From: Nicola Spencer
Sent: 05 October 2015 17:49
To: [REDACTED]
Subject: Notification for Prior Approval AL/91/15/PD

Prior Notification for Prior approval for a proposed change of use from Cattle and storage Barn (agricultural building) to dwelling house (class C3)

SITE PLAN

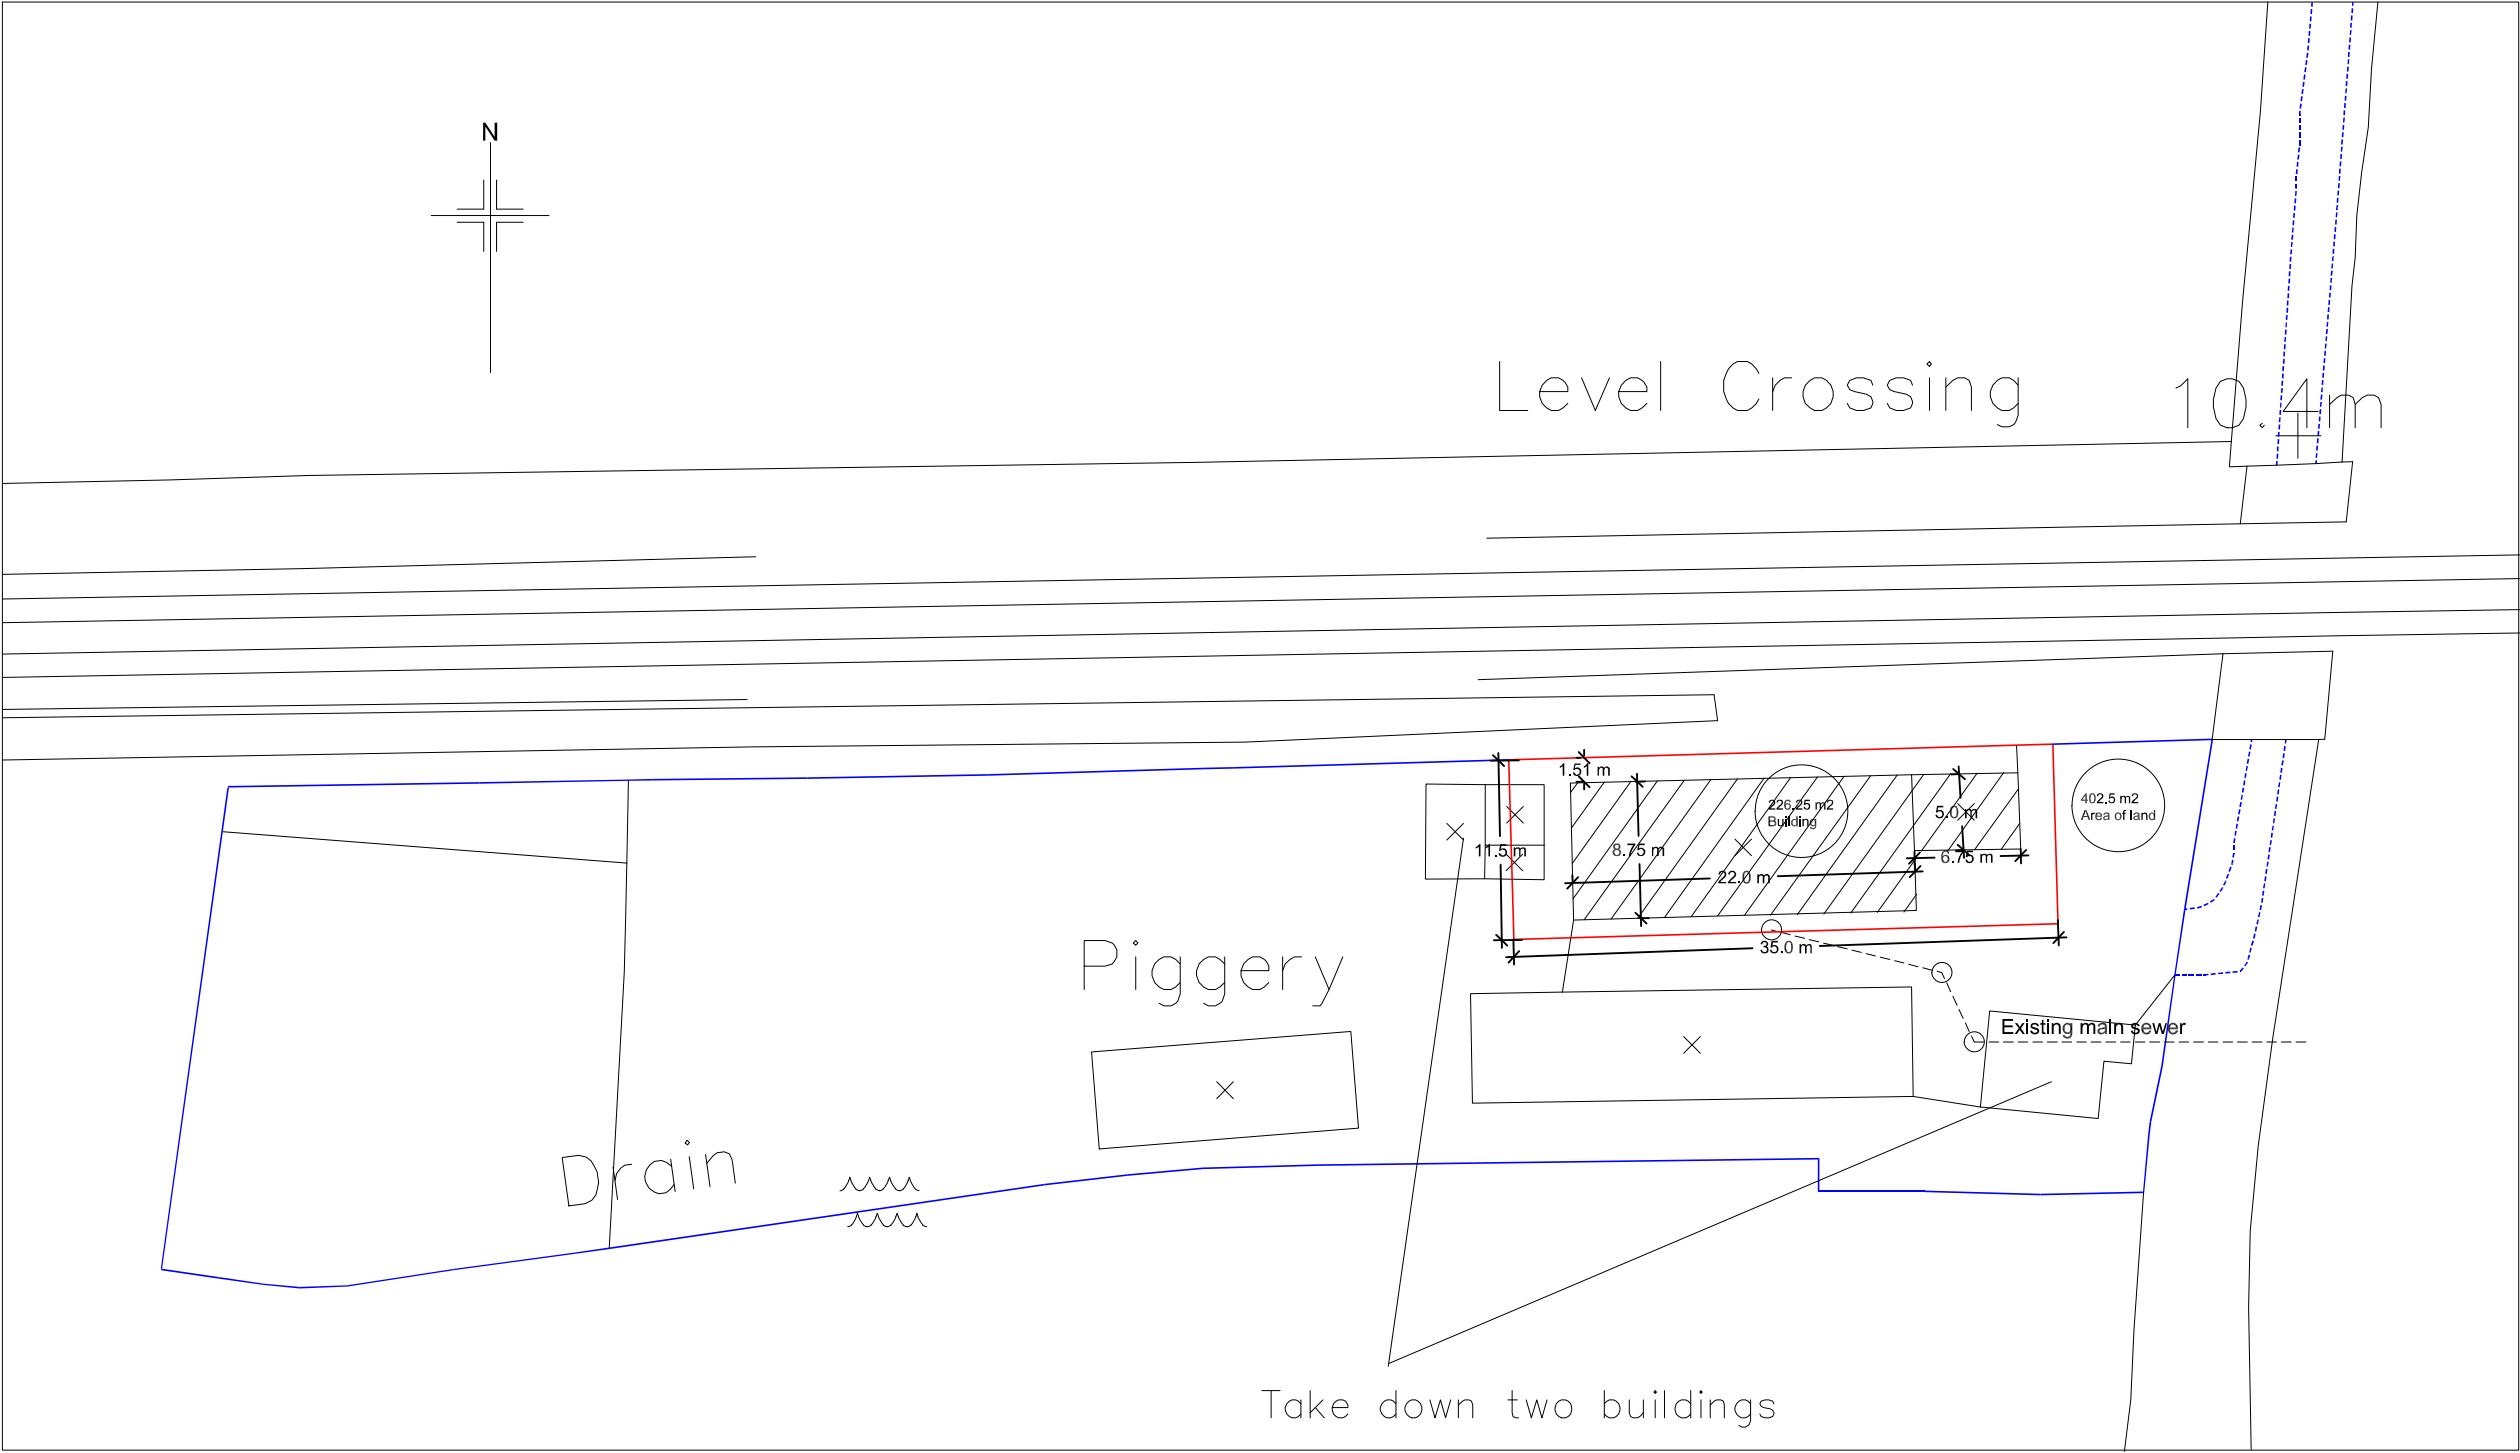
Thank you for your recent notification for prior approval and the amended Page 2 of the application form. Unfortunately I am unable to accept this as a Notification for prior approval for a change of use from an agricultural building to a dwelling house as the curtilage is still too large to enable it to be treated as a prior notification. You will have to apply for a formal planning change of use using the normal planning application form.

‘ a) The piece of land, whether enclosed or unenclosed, immediately beside or around the agricultural building , closely associated with and serving the purposes of the agricultural building, or
b) an area of land immediately beside or around the agricultural building no larger than the land area occupied by the agricultural building,
whichever is the lesser ; ‘
